Interested Party Reference: 20047795

27th November 2024

**Mona Offshore Wind Farm:
Response to ExQ2: 19 November 2024 on Behalf of Tan-y-Mynydd Trout Fishery**

Figure 1.6: Onshore Substation Options Indicative Construction Layouts

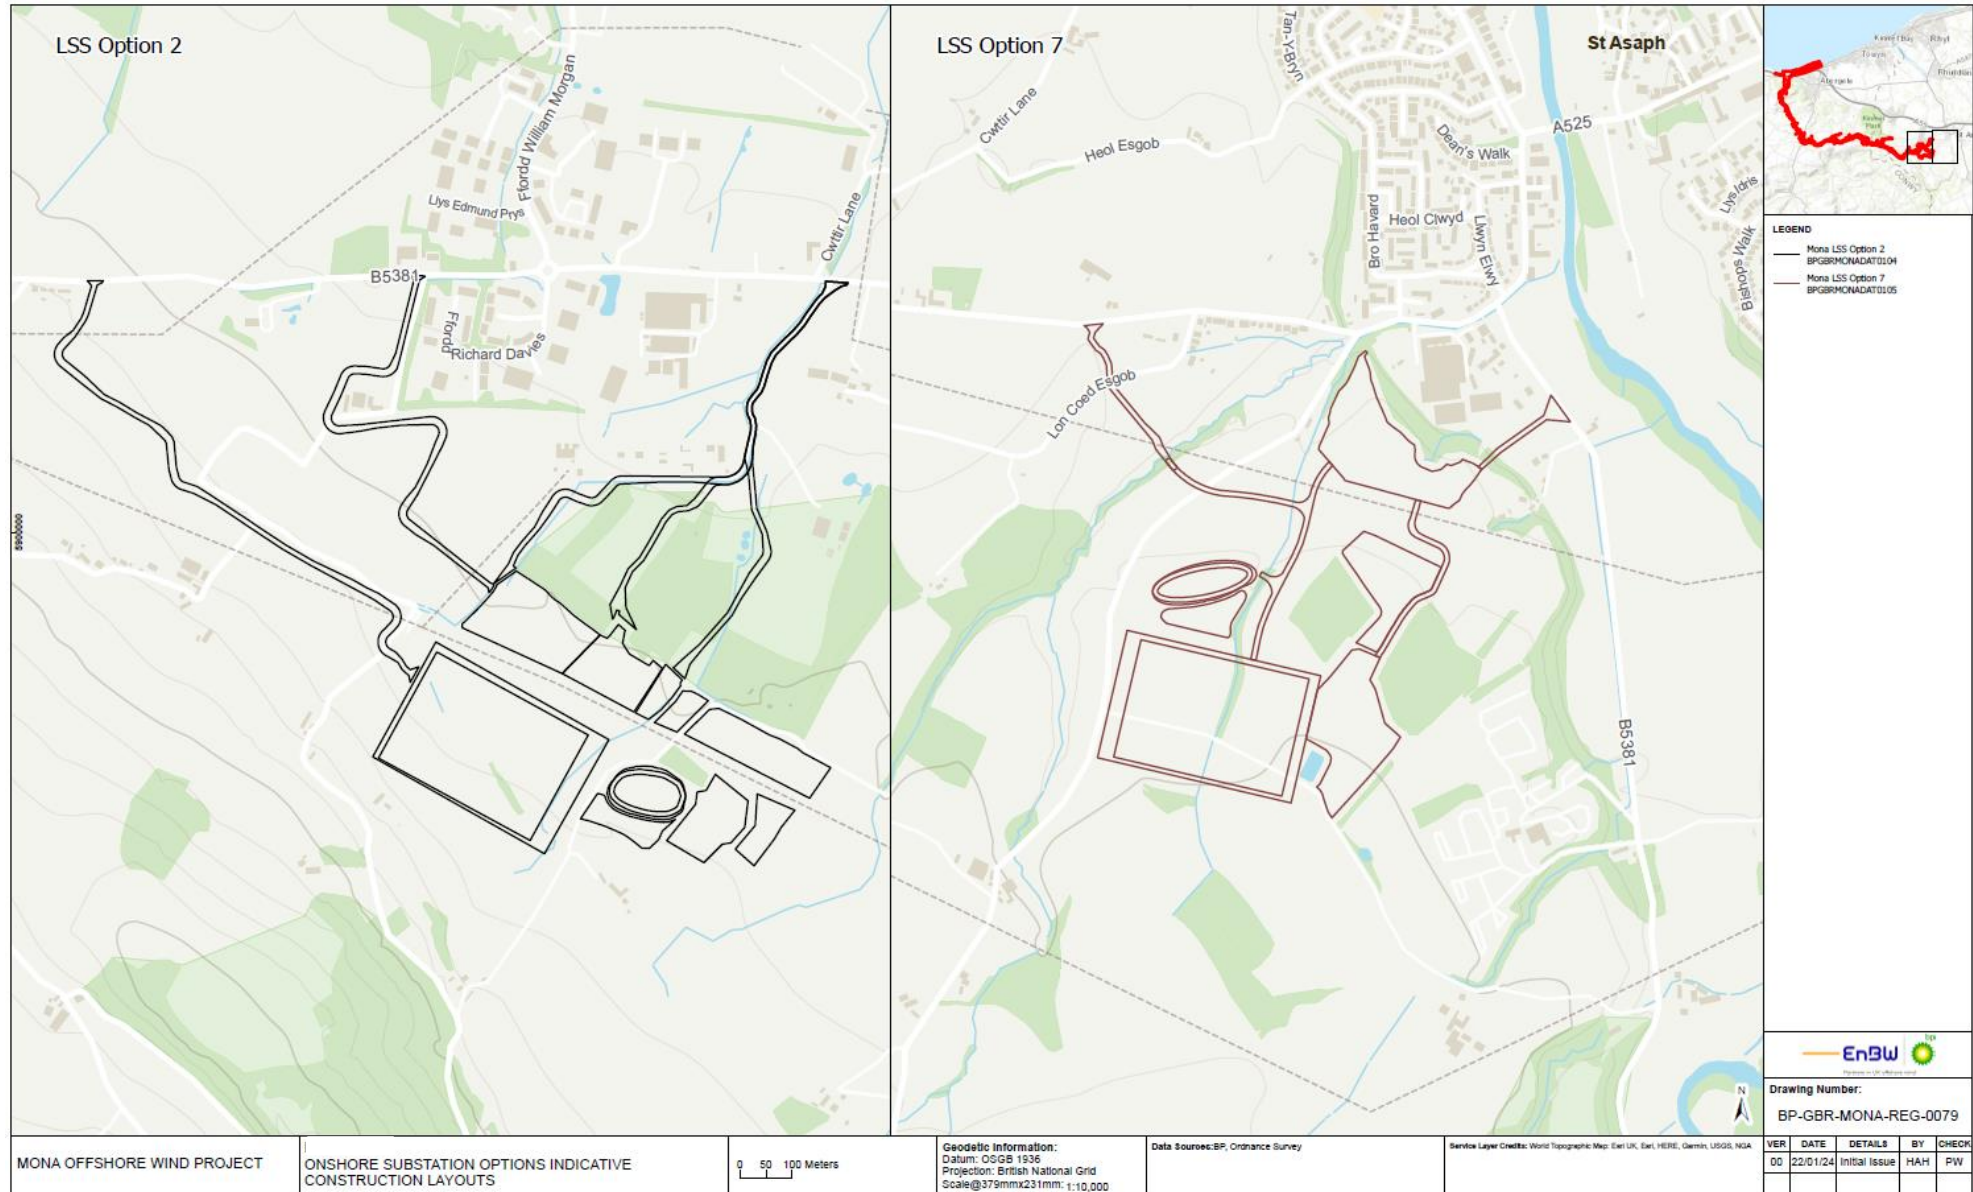
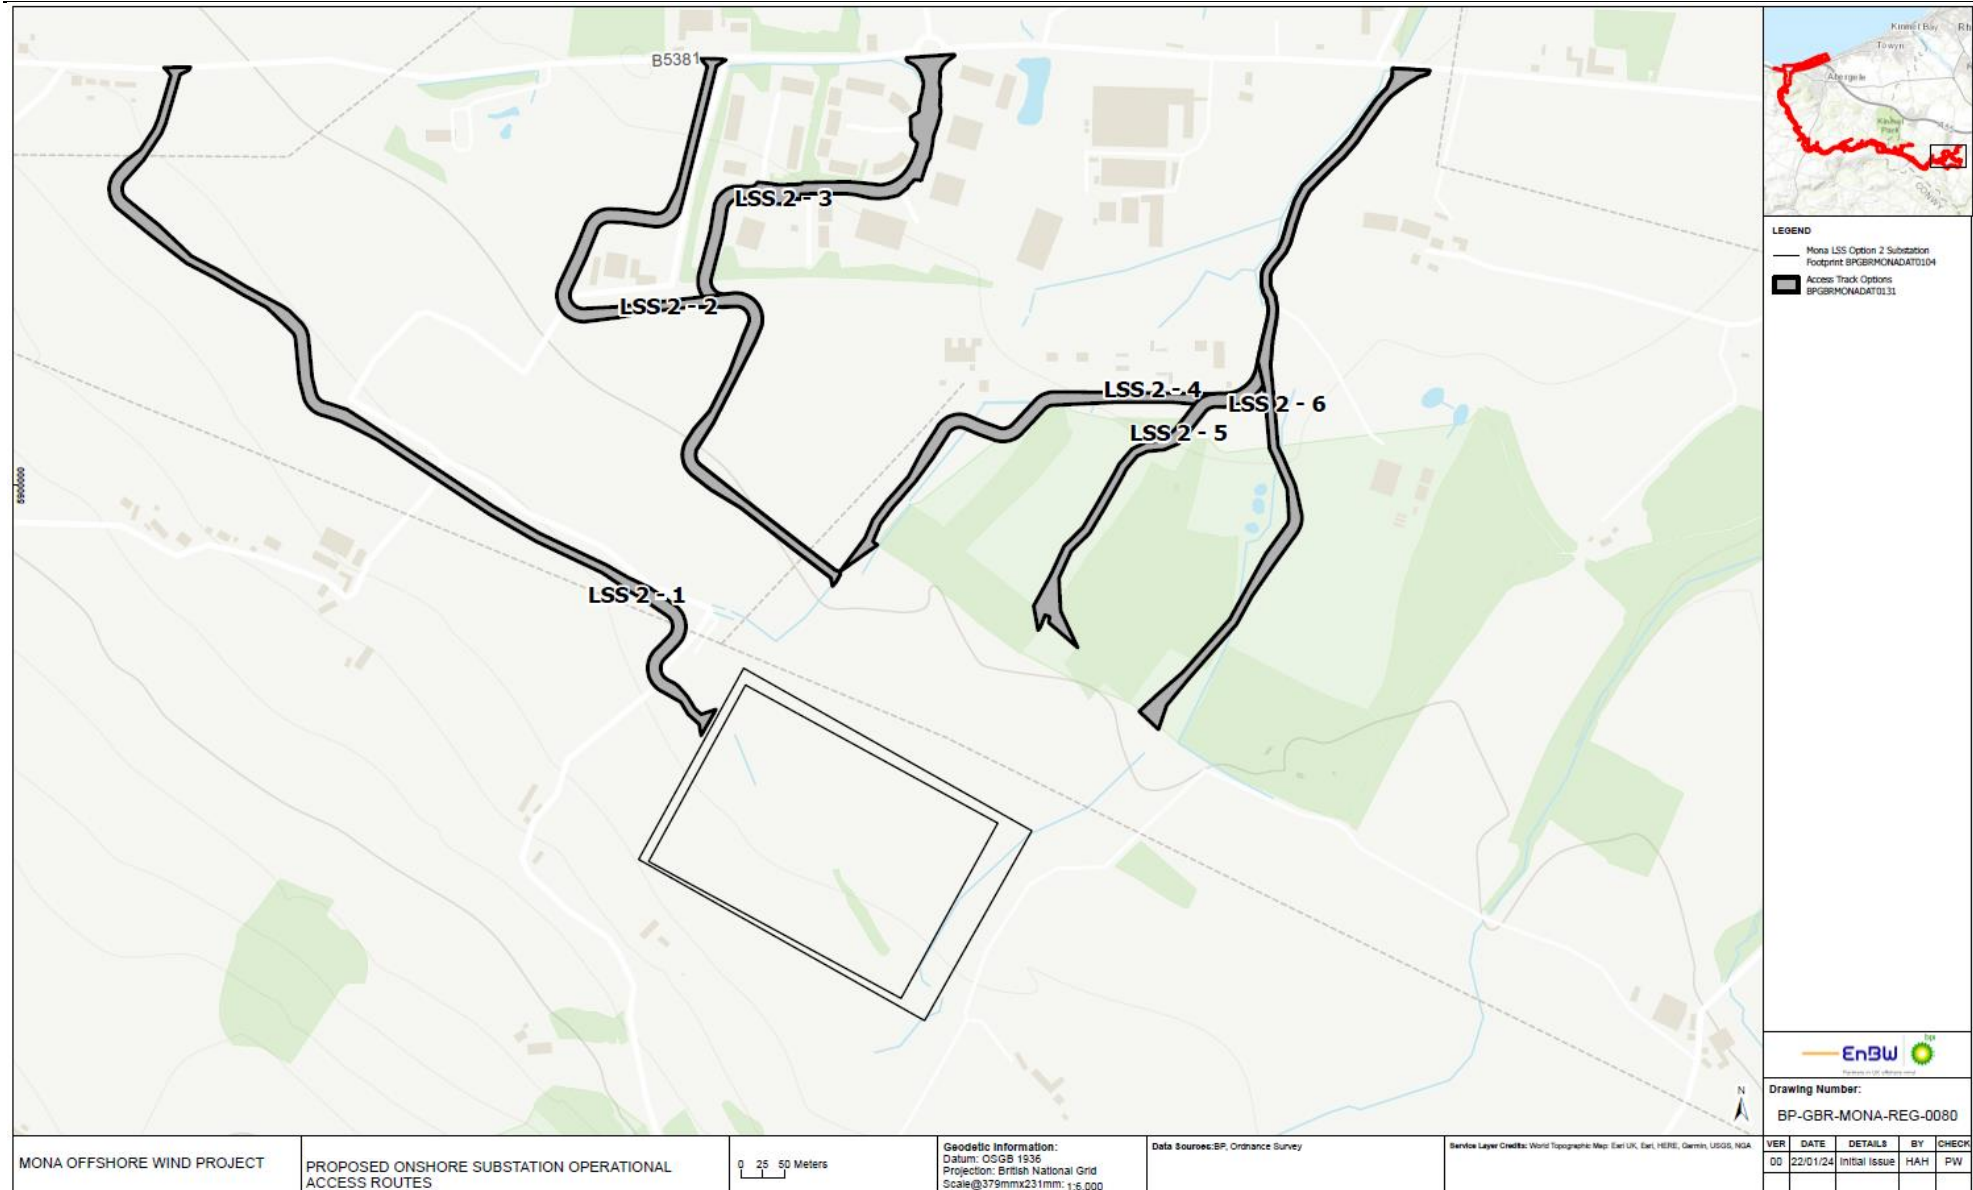
Rep3-107.01: The BRAG report has been received. Sadly, it is very light and 'very subjective', in its consideration of the impacts on the water sources enjoyed by the fishery. This is particularly the case regarding it adopting the Southern cable route. Indeed, based on the overall BRAG report, we would venture that the fishery water sources were at best an extremely minor area of consideration in the grand scheme of route selection.
